# **OXFORDSHIRE COUNTY COUNCIL'S RESPONSE TO CONSULTATION ON THE FOLLOWING DEVELOPMENT PROPOSAL**

**Application no:** 16/00264/FUL

**Proposal:** Construction of a road with associated infrastructure within the Heyford Park development

**Location:** New Access Road Adj To Camp Road Upper Heyford

BUS ROUTE WITHIN PHASE 5 APPLICATION

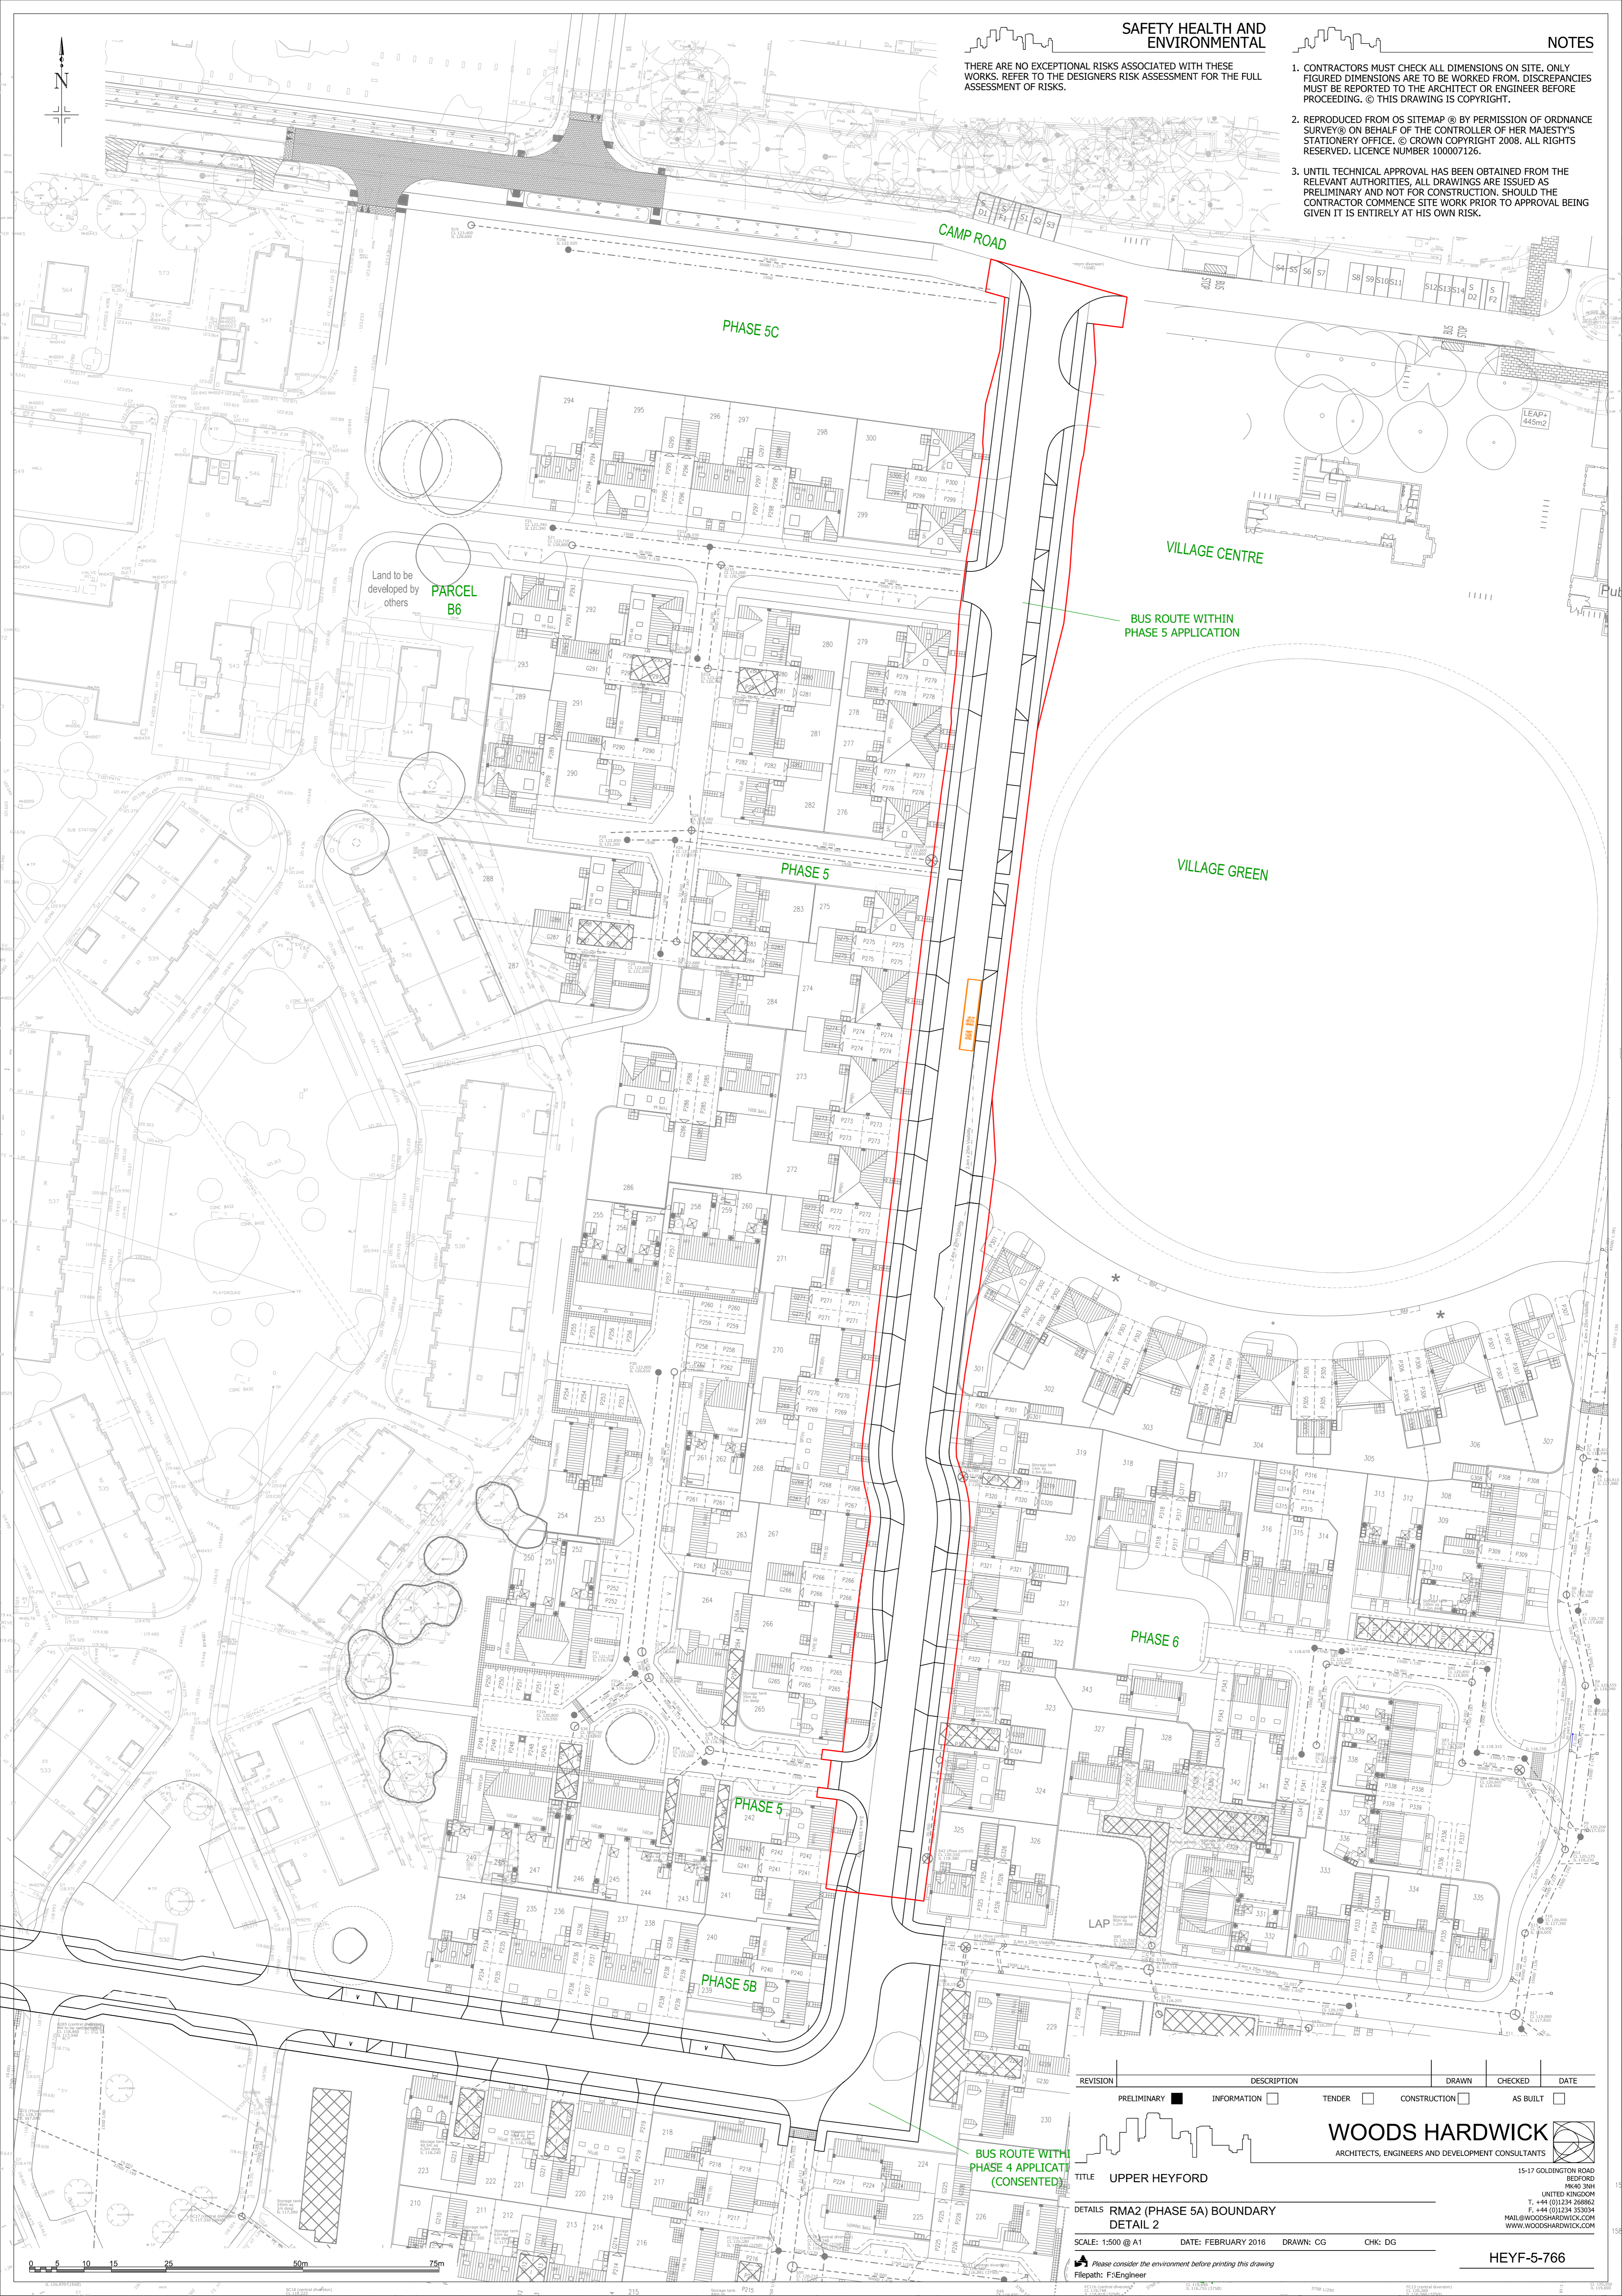
The application needs to be reassessed to take into account existing and future bus service routing in and around the Upper Heyford area. The road subject to the application is unlikely to be used by public buses.

The current 25A bus service is not commercially viable. It must attract additional patronage from the new residents to bridge the gap between costs and revenue. To do this the service must be attractive, reliable and direct, and not constrained by routing around slow residential streets as this application appears to propose.

The current 25A bus service is scheduled to make the journey between Bicester and Oxford (via Upper Heyford) in approximately 55 minutes with two buses providing an hourly service. There is simply insufficient time in the schedule for this bus to make a detour around narrow slow-speed side roads, encumbered with build-outs and parked vehicles. The economics of this bus operation cannot sustain the cost of an additional vehicle which would be needed to cover the additional time required for this detour around the residential area.

Successful bus services are based on direct operation along main roads, with users walking to appropriately located bus stops on such roads (Camp Road). 'Held' and 'secured' Section 106 funds are currently required to be deployed to create a commercially viable bus service. If this cannot be achieved, then there will be no bus service to and from Upper Heyford in the future.

The developer should concentrate on providing a 'bus-friendly' route along Camp Road, without severe vertical calming measures, to help build an enduring and successful public transport service to and from the Upper Heyford area.

Adverse comment about the promotion of this narrow slow route around the residential streets has been made before, but has not been heeded. A meeting is required between relevant parties, to ensure an agreed level of public transport can be provided to the Upper Heyford area in the future.

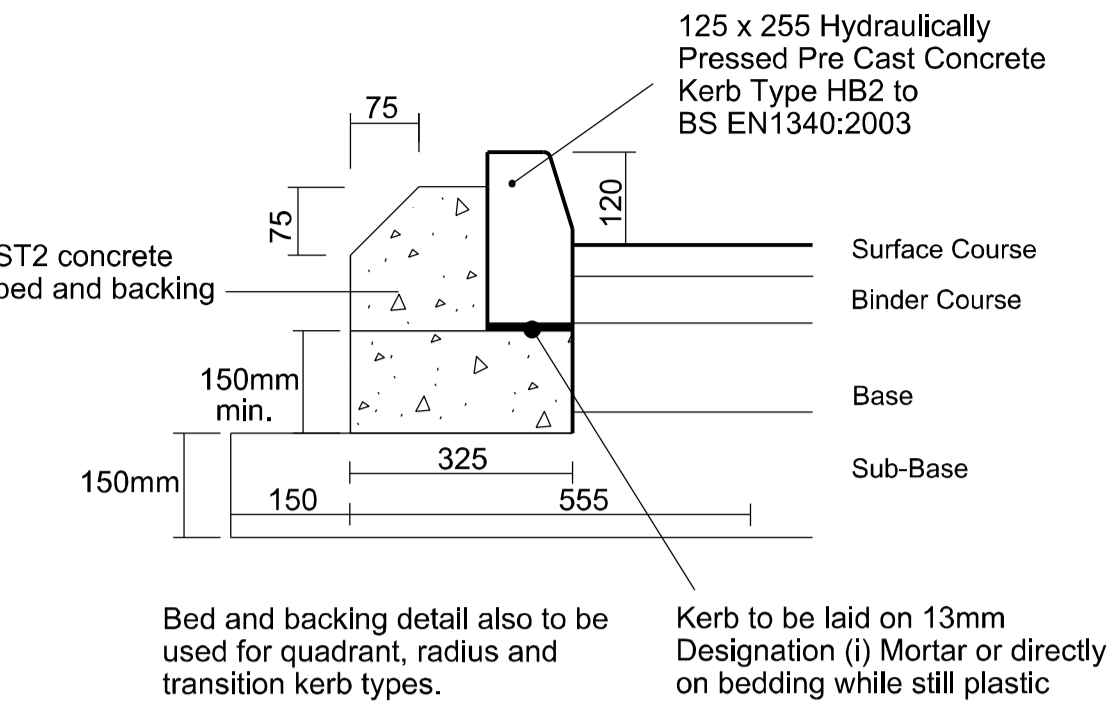
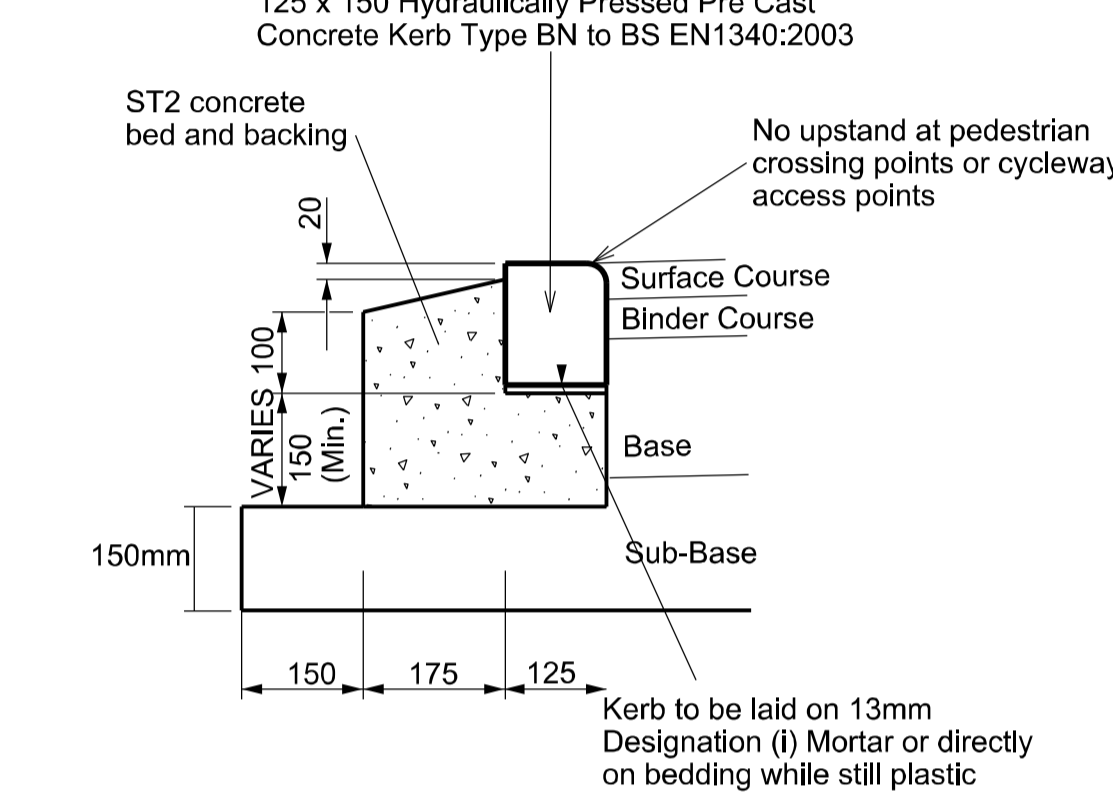
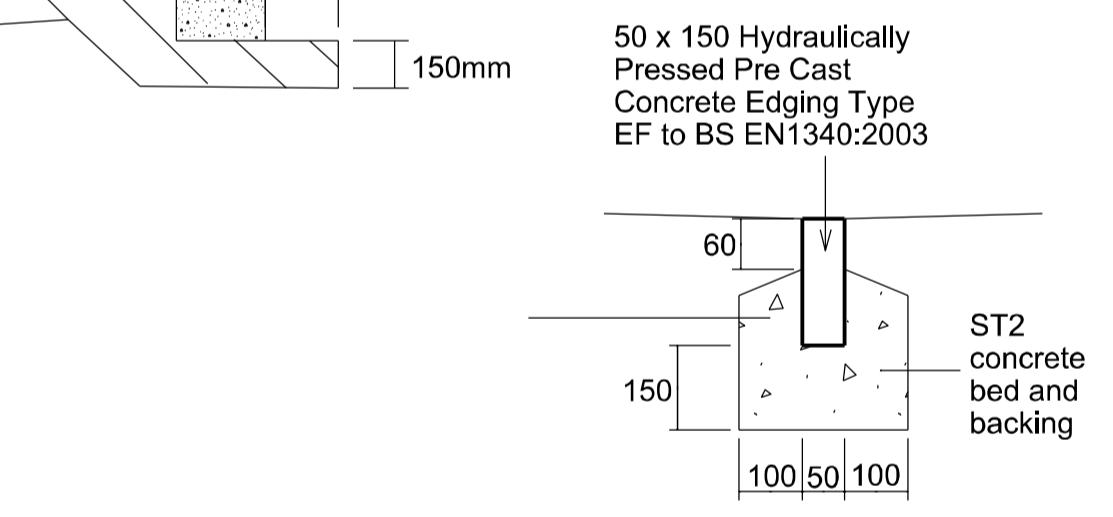
The specification on the Typical Construction Details plan no.HEYF/5/765 is not to an acceptable standard. The tarmac penetration specification should be 100/150Pen for surface course and binder for footway and vehicle crossovers with 150mm lean mix concrete as sub base.
